M25 junction 10/A3 Wisley interchange

TR010030

9.27 Response to RHS Comments on Air Quality

Rule Number:	Rule 8(1)(c)(i)
Planning Inspectorate Scheme Reference	TR010030
Application Document Reference	TR010030/9.27
Author:	M25 junction 10/A3 Wisley interchange project team, Highways England and Atkins

Figure 3-1 Layout of south-facing slips at Ockham as proposed by RHS

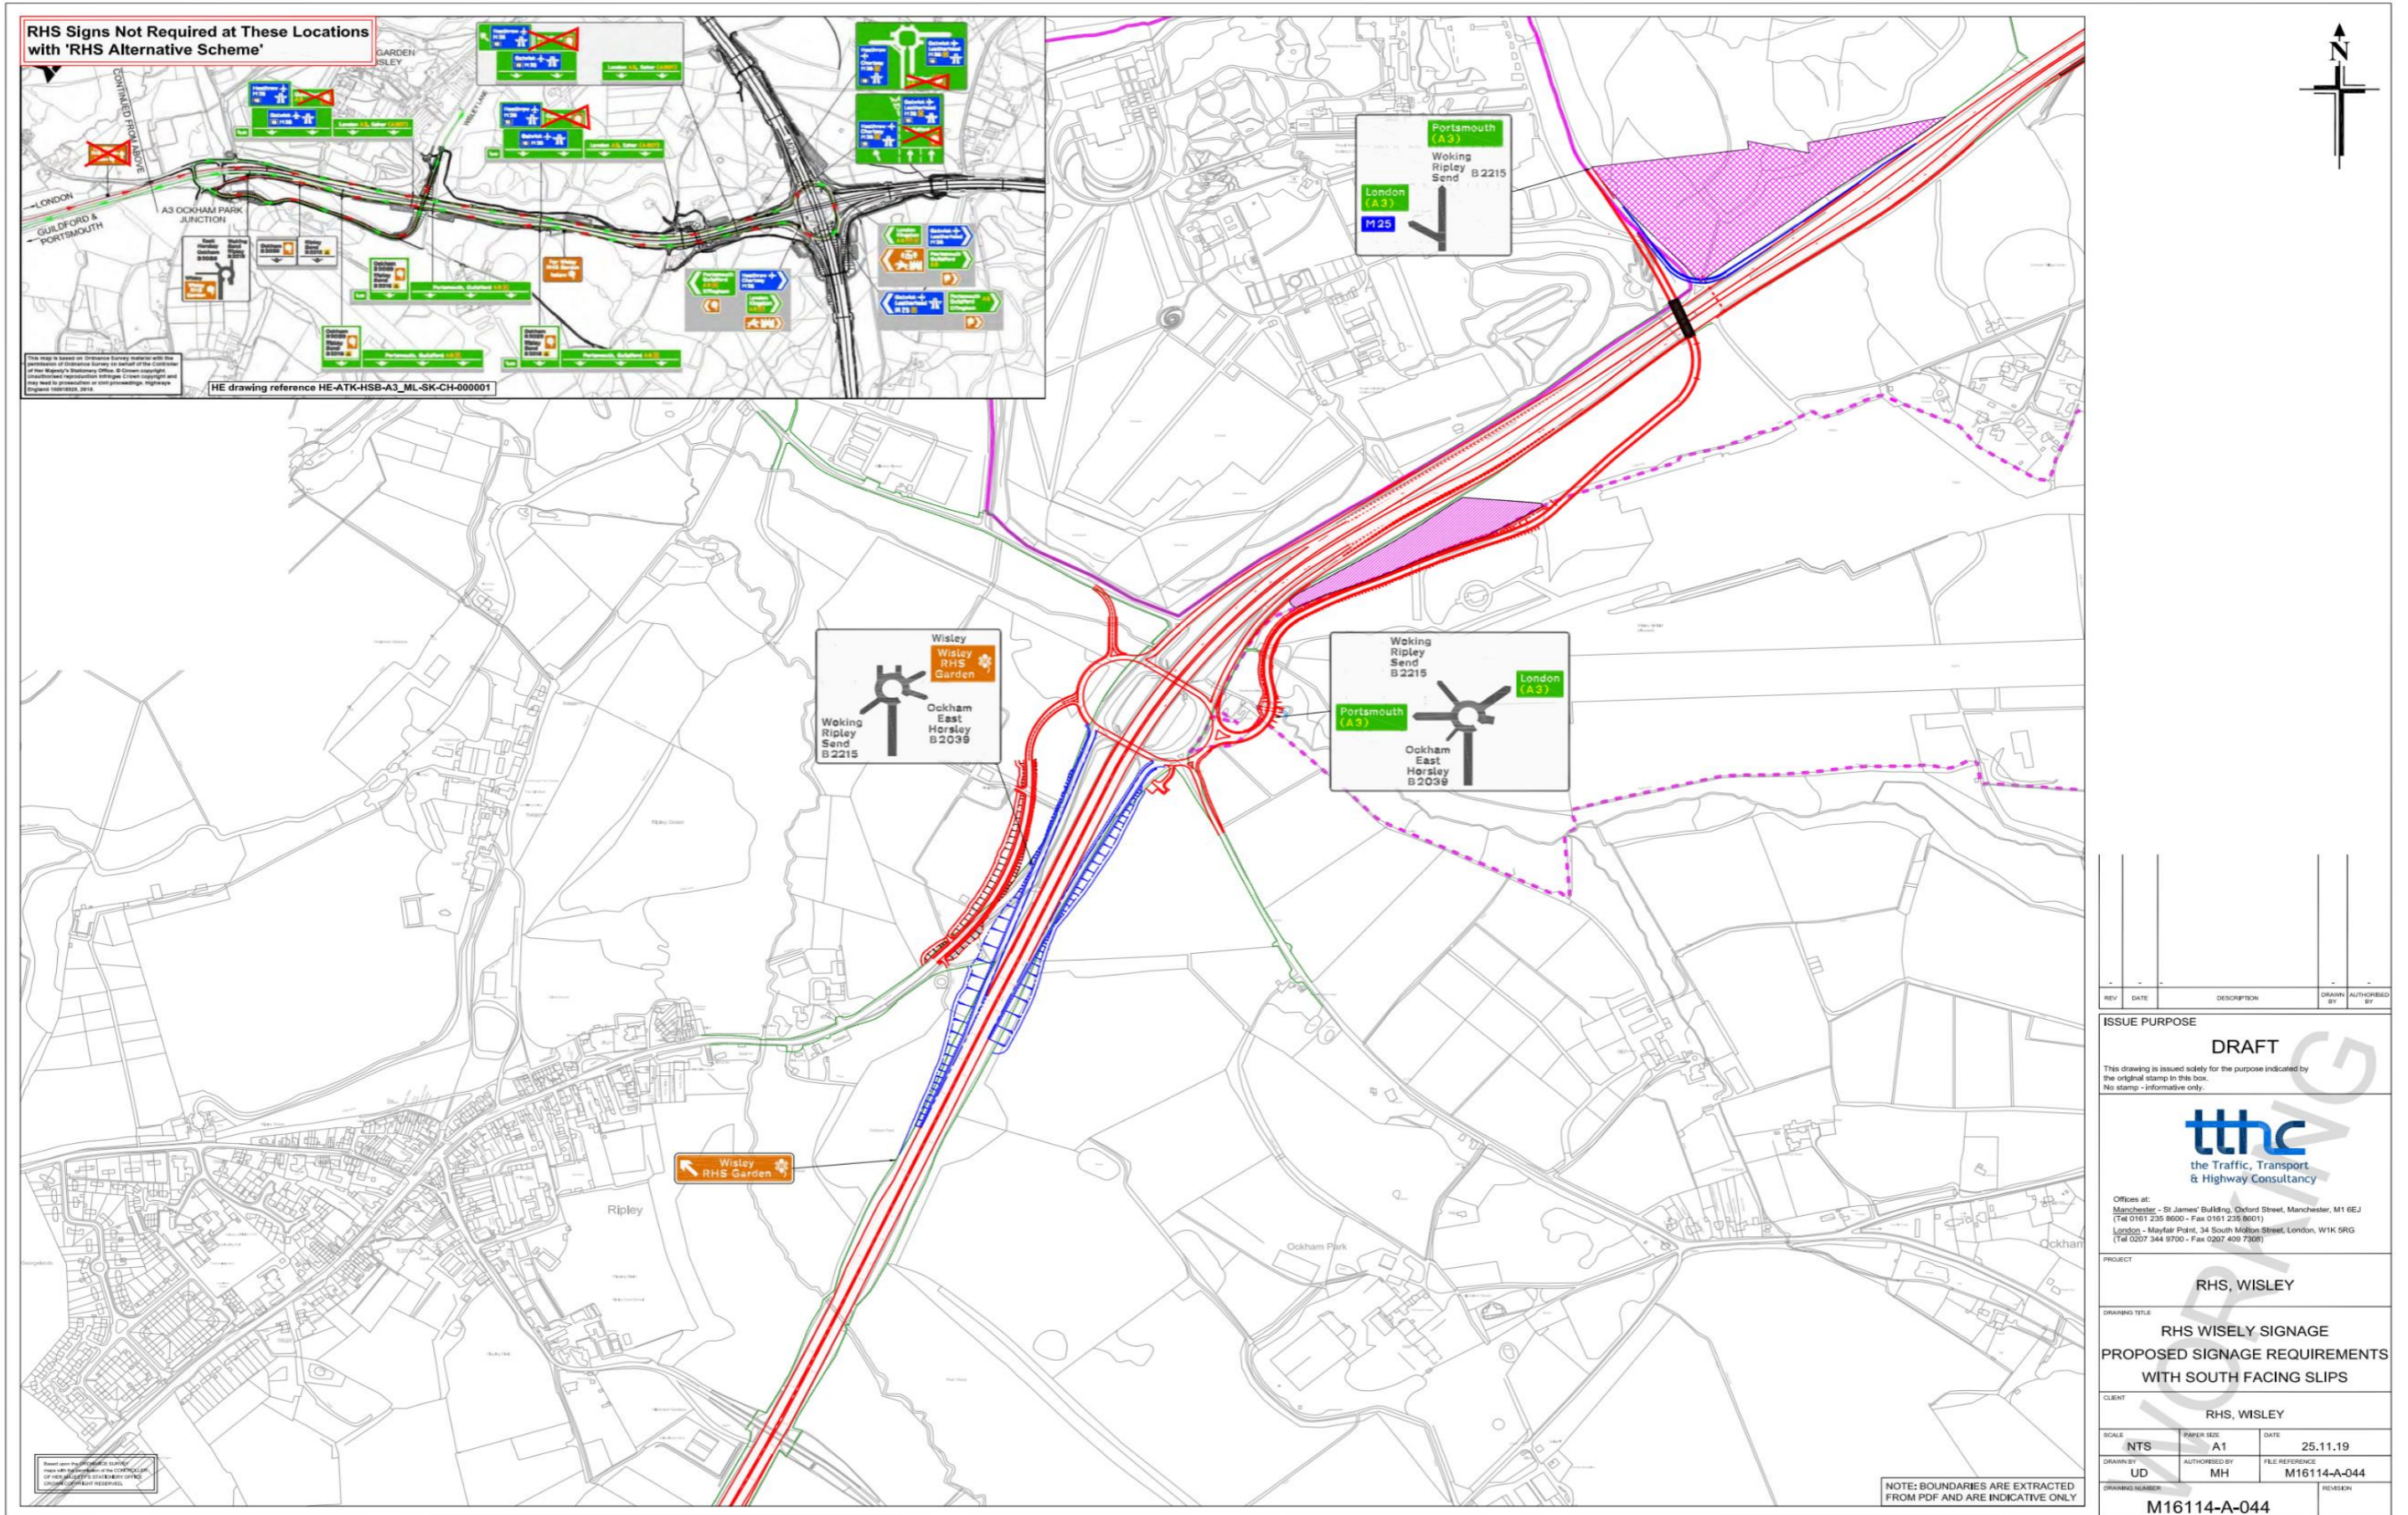
- 2.4.1 The RHS Alternative includes south-facing slip roads for the A3 at Ockham roundabout. The south-facing slip roads at Ockham roundabout are not included in Highways England's Scheme, and have not been assessed. However, it would not be unreasonable to assume that the effect on the Thames Basin Heaths SPA would be similar to that assessed in the ES, as both the Alternative Scheme and the Scheme as assessed route traffic from the south to Ockham Park junction via south facing slips (Alternative scheme) or via Ripley (Scheme) and not via a u-turn movement at M25 j10.
